**Submission on behalf of Jacfin Pty Limited
Energy from Waste Facility (SSD 6236)
Premises: Lots 1, 2, 3 and 4 in DP 1145808, Eastern Creek**

Jacfin **objects** to the development application for the proposed 'Energy from Waste Facility' (the **Facility**) by The Next Generation (NSW) Pty Limited at the Premises, for the reasons outlined in this letter and in the enclosed review undertaken by leading town planning experts, JBA Urban Planning Consultants Pty Limited (**JBA Report**).

PROPOSED SITE MASTERPLAN

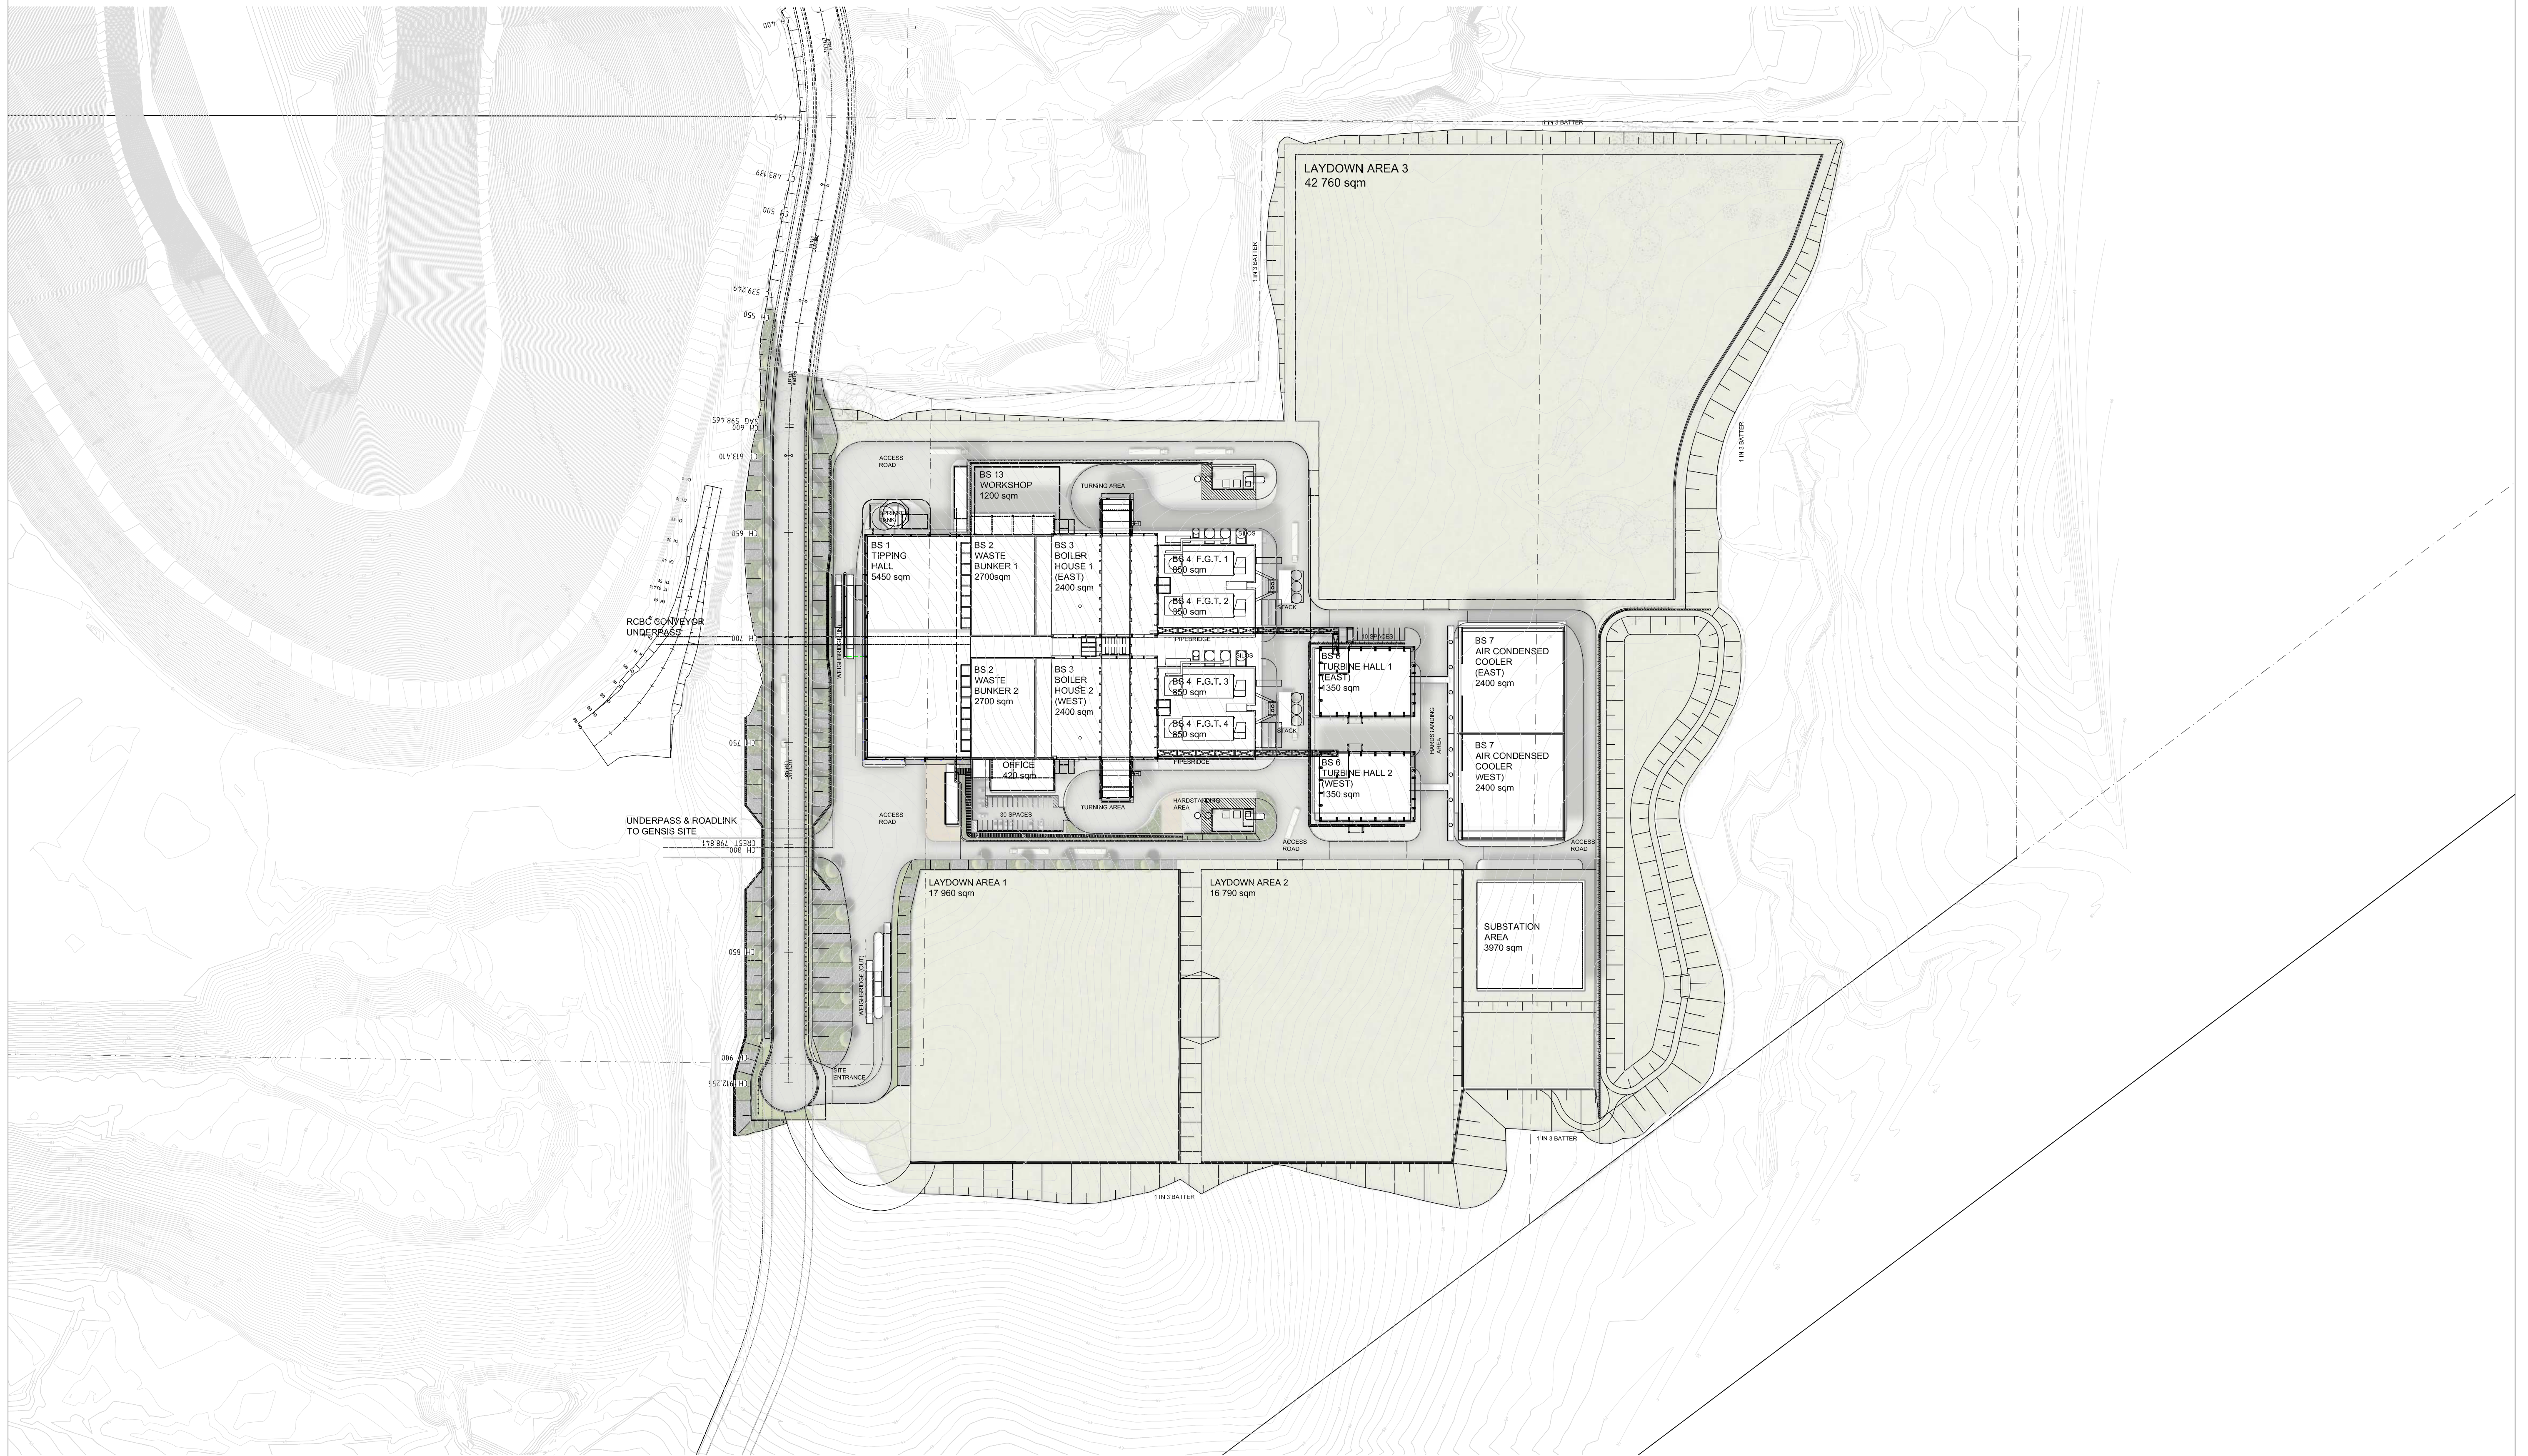
- Additional planting along the southern boundary of the Premises (to the south of the bio-retention basin) be included as a requirement of a Landscaping Plan. This should be consistent with maintaining the vegetation visual catchment indicated under the Eastern Creek Stage 3 Precinct Plan⁹.

The EIS does not contain any detailed information about the bio-retention pond located on proposed Lot 4 and close to the boundary of our client's site. Similarly, there is little information regarding the treatment of the area within the riparian setback to the Ropes Creek Tributary near the southern boundary of the Premises.¹²

- Further information is required about the construction and proposed operation of the bio-retention pond to ensure it does not become a source of odour or pollution; and
- Further information is required on the establishment and management of the area within the riparian setback and the land between the southern boundary and the riparian area.
